FRIEDMAN HOMES

Mercer Island Development department:
RE permit # 2112-254

I re-submitting for intake the submittal for 8005 SE 34th Pl. Mercer Island. Below is my response to the initial intake response.

8005 SE 34TH PL RESIDENCE
JON FRIEDMAN
GRADING AND UTILITY PLAN

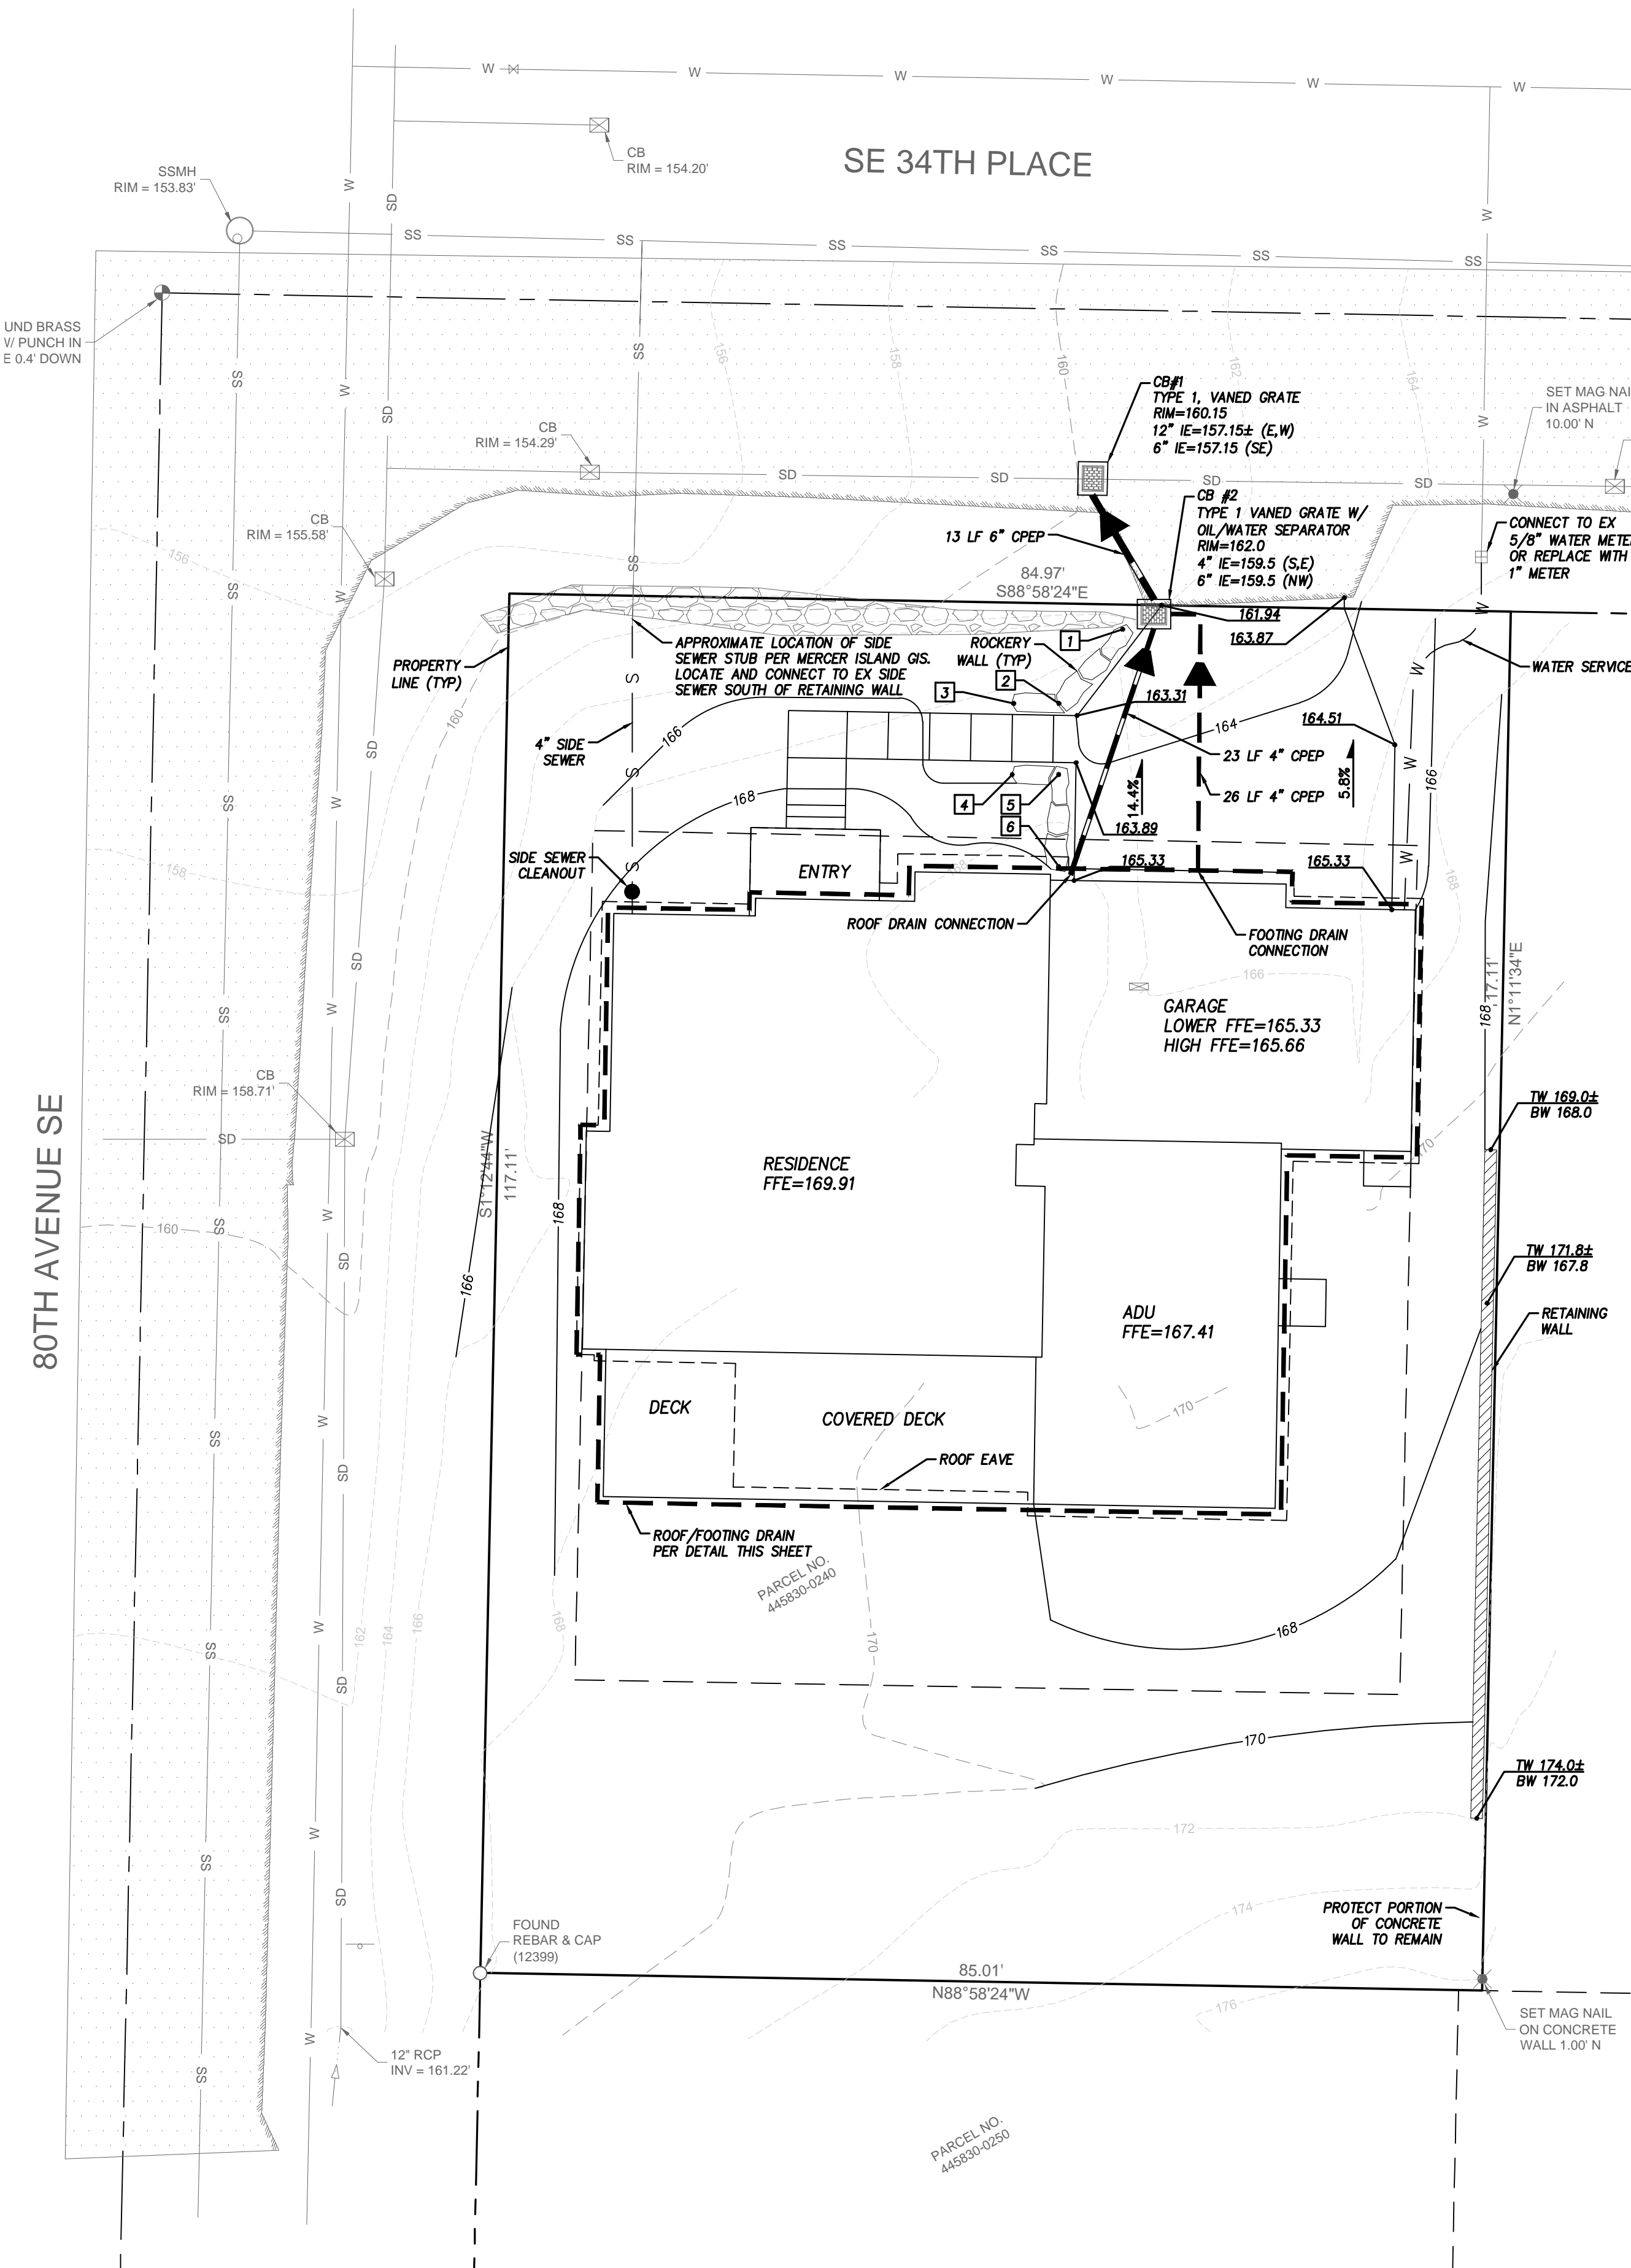
- Indicate existing grade and finished grade

Response: included on 3 – utility plan. Applicant can include detailed existing and finished grade on elevation sheet/s at initial plan review request.

BASEMENT EXEMPTION

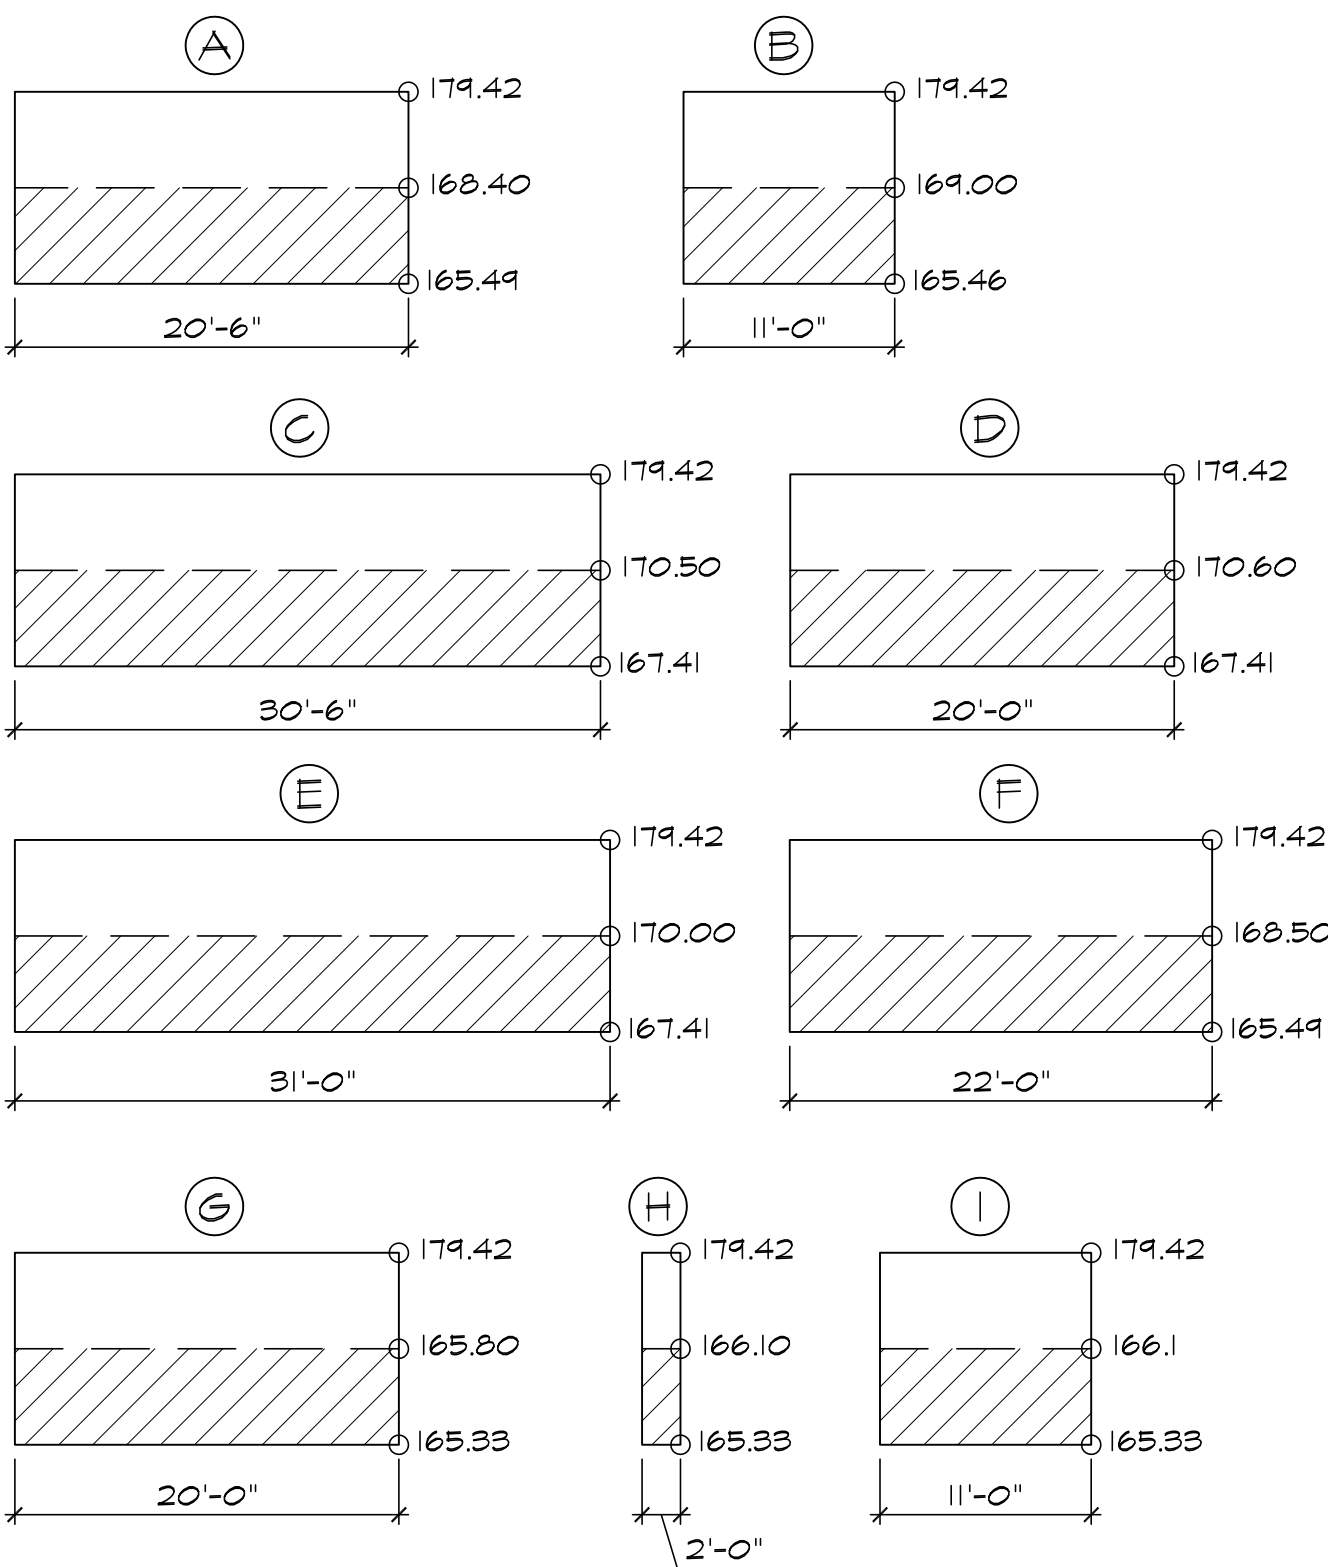
- Provide calculations for any basement areas being excluded from allowable gross floor area.

Response: Calculations for basement area included on A0-site plan. Also referenced on site development worksheet. Applicant can include calculations on elevation sheet at initial plan review request.

SITE PLAN

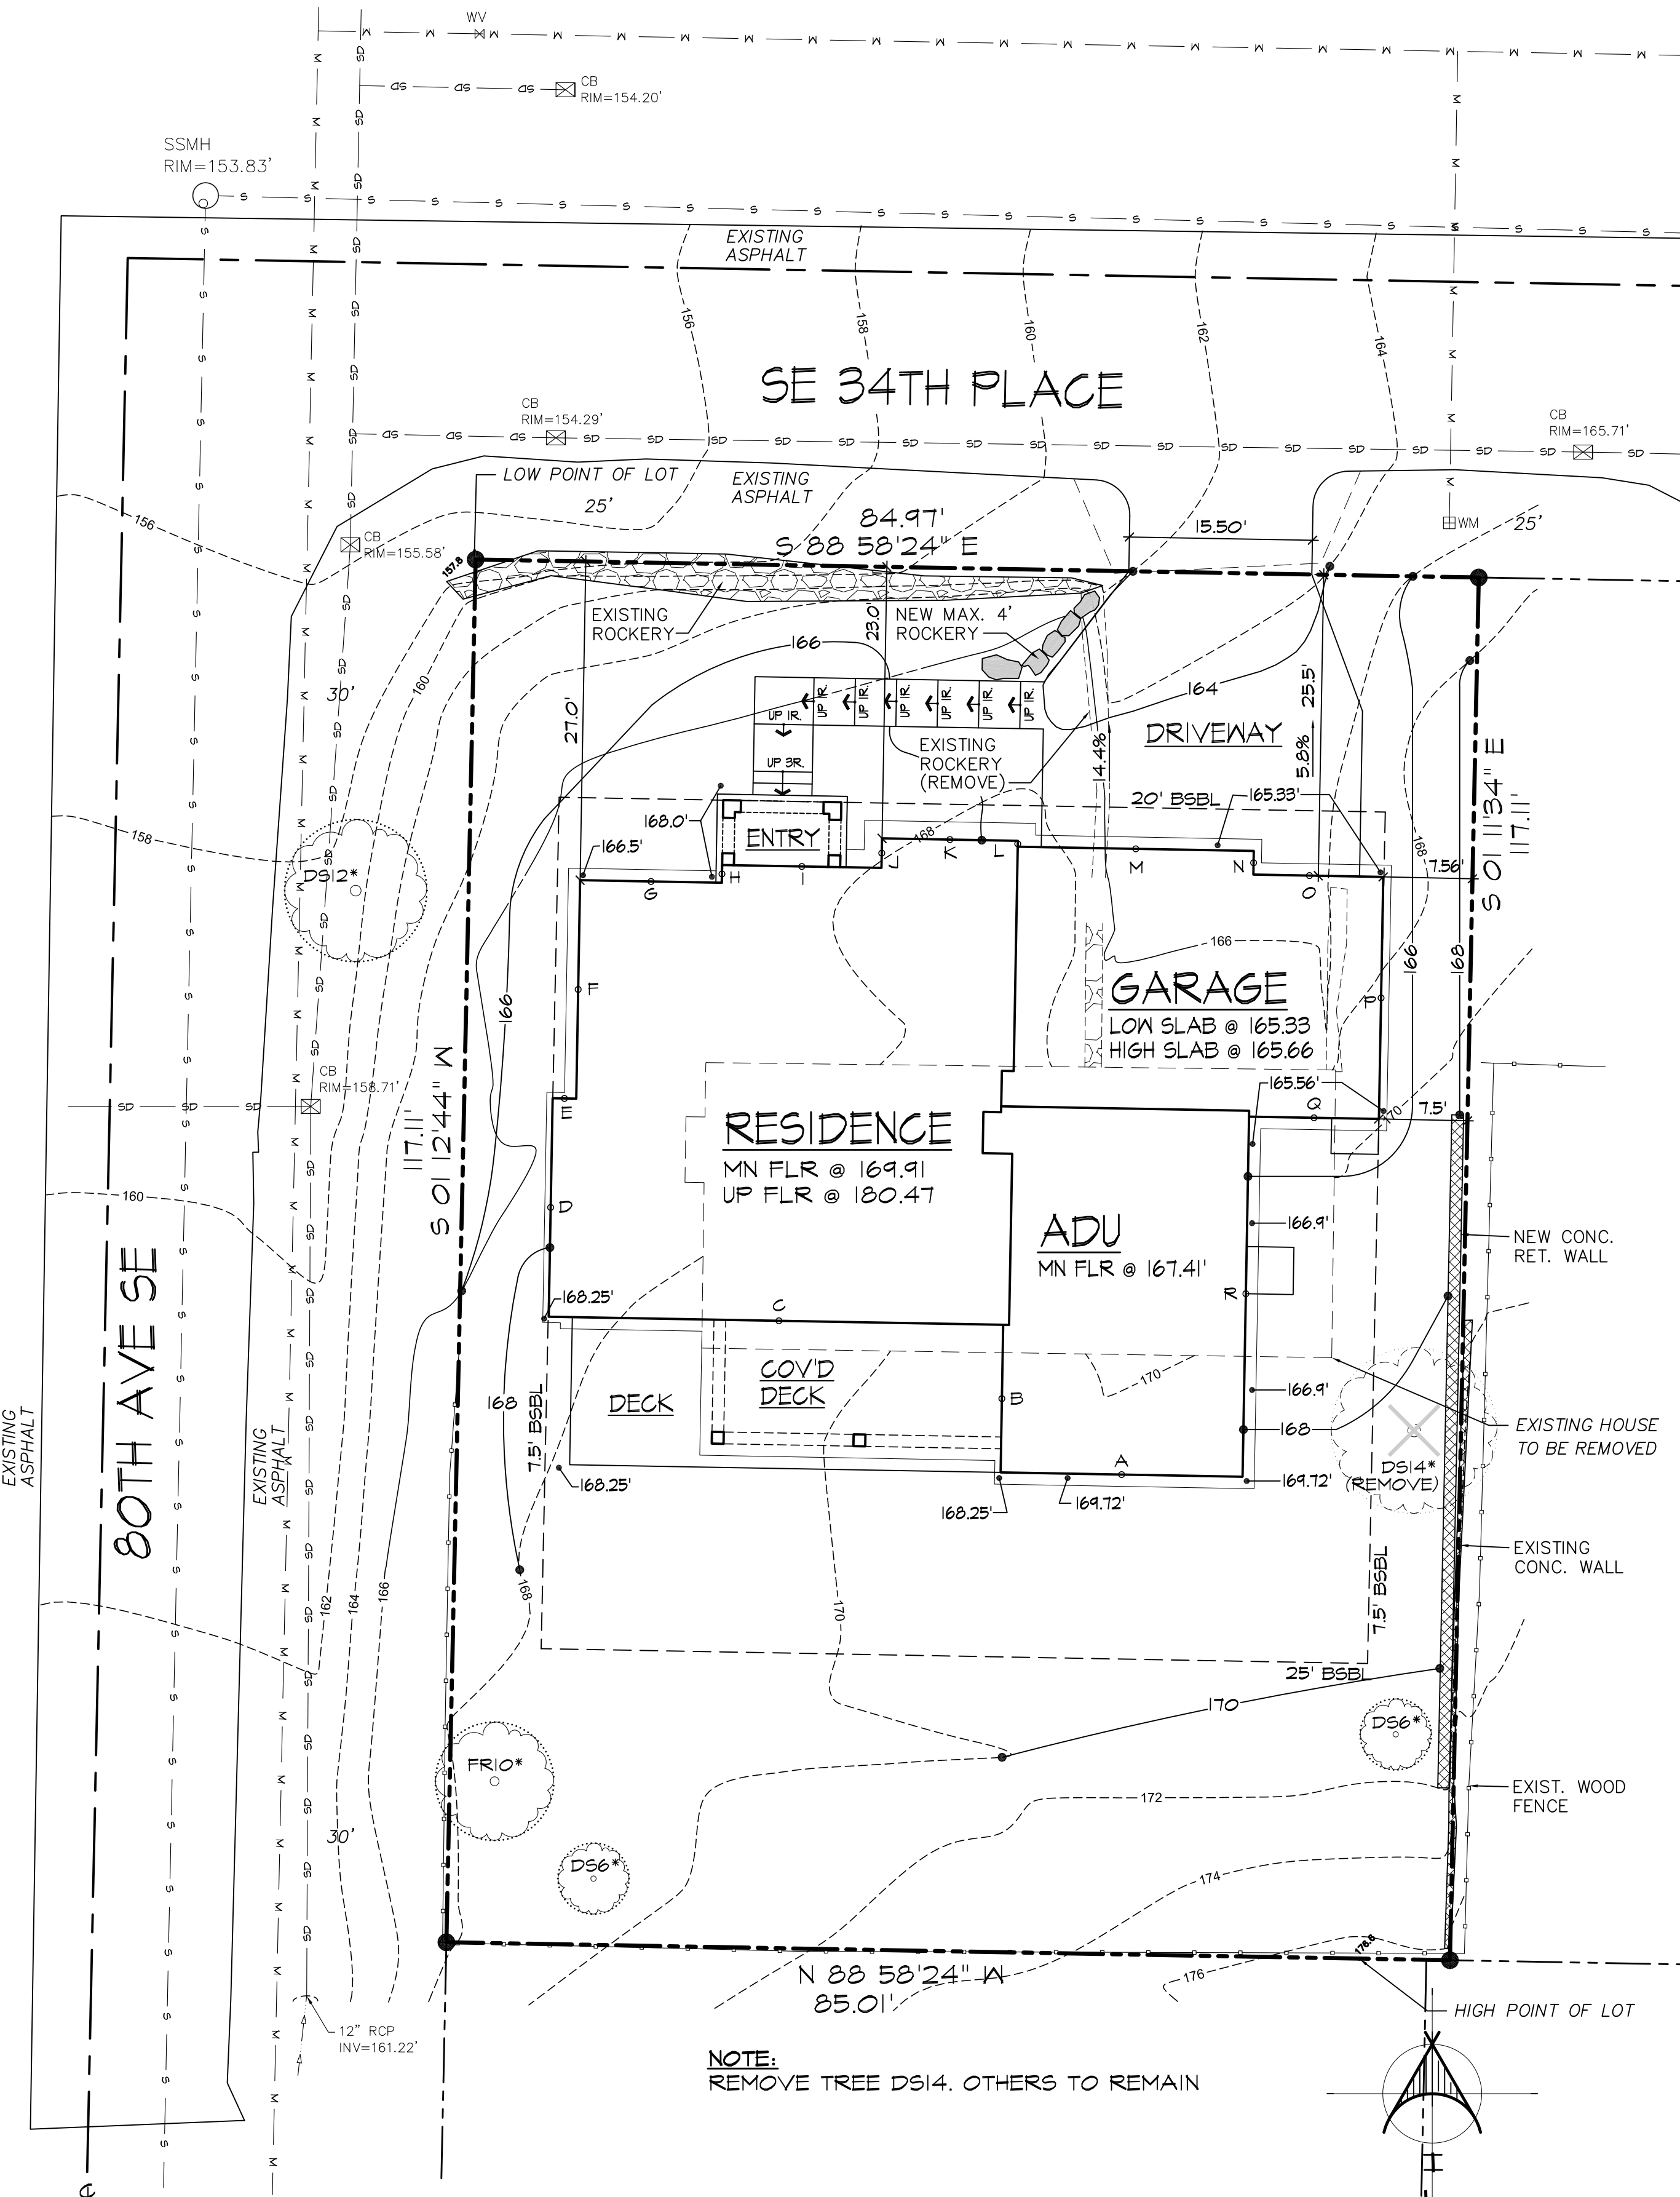
- Indicate required yard setbacks

Response: required yard setbacks are included at A0 – site plan
